5th October 2026

Re: Application Reference 2026/59/92523/E
Land off Ing Head Lane, Thurstonland, HD4 6XG

Drawing Title.
**SITE / LOCATION
PLANS AS PROPOSED**

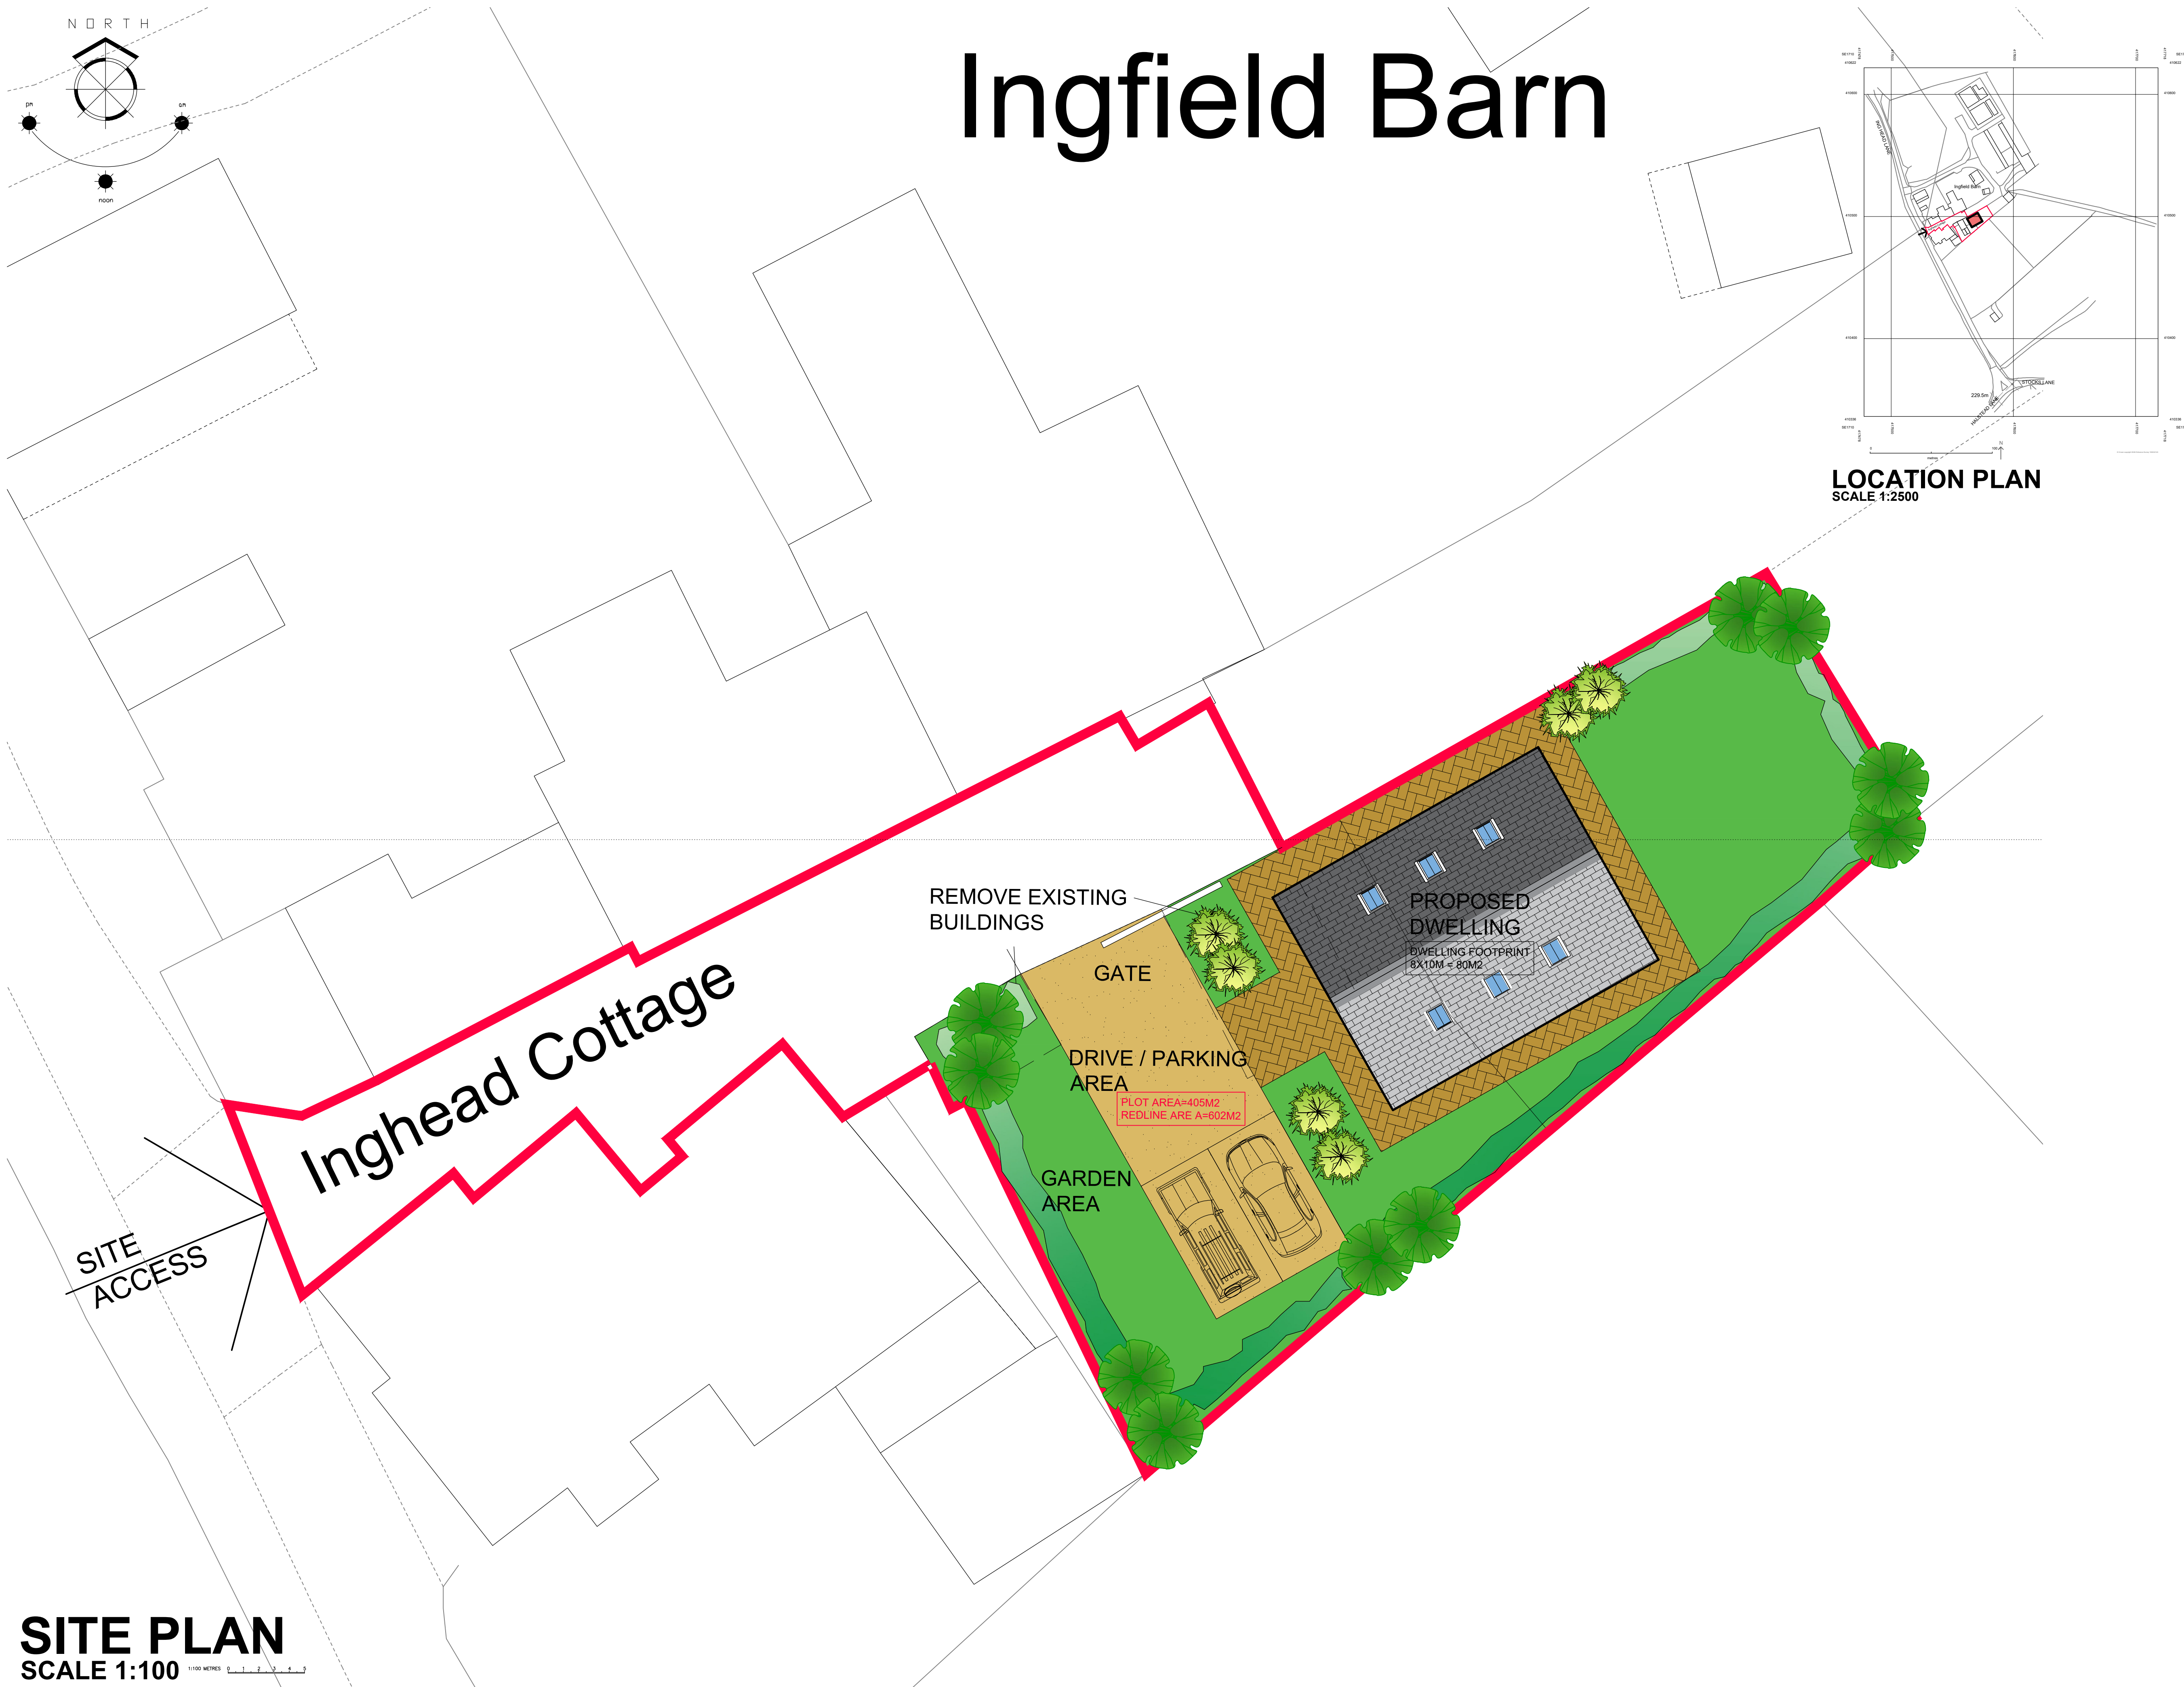
Whilst as a Permission in Principle the Applicant is not required to submit extensive documentation and details, from the indicative plan provided there are clear concerns regarding the visual impact of the development in relation to scale and design, the loss of existing vegetation and the potential erection of new boundary treatments. In addition, the scheme will likely result in direct overlooking of neighbouring properties and will result in an overall feeling of a loss of privacy. Loss of light and amenity to the neighbouring properties could well be oppressive, with the overall scale of development likely in our view to represent overdevelopment of the plot. In that regard, the development will overbear the neighbouring sites and result in harm to the wider site. It is clear that the scheme will result in a scale and siting of development out of keeping with the local area, and one which results in a cramped appearance. The resultant harms from these elements are in our view sufficient to justify refusal of this Permission in Principle.

Additional concerns relate to the highway impact of this development, including the legality of the submission on site access. The Applicant has correctly red lined the driveway access to the site, however our clients, once their purchase is complete, will actually own the access road, which in itself raises questions on the deliverability of the plot and right of access.

The need to ensure that vehicles can safely turn and manoeuvre within the site boundary such that they can enter and exit the site in a forward gear, including during the construction phase, also needs to be explored in relation to the assessment of this scheme. As does the matter of parking, in circumstances where there are a number of existing properties with doors that open directly onto the

access road, meaning that the accessway simply cannot be used for vehicle parking associated with this proposed development. Our client is therefore concerned that this could lead to vehicles needing to park on Ing Head Lane itself, and resulting in a further narrowing of the highway in an area already poor in visibility, and potentially leading to congestion and highway safety concerns.

In relation to the amenity standards of future occupants of the dwelling proposed, we are concerned that the proposed indicative layout indicates a development somewhat cramped in appearance given the tight nature of the application site boundaries. It is essential that new homes not only meet the requirements of Nationally Described Spacing Standards, but also deliver a high quality and satisfactory standard of living accommodation for future residents. We therefore kindly ask that the case officer undertake a site visit, if not already done so, to fully understand the nature of these concerns, and to make a suitable assessment to ensure that the site can in reality accommodate a new dwelling, access, parking, garden areas etc.
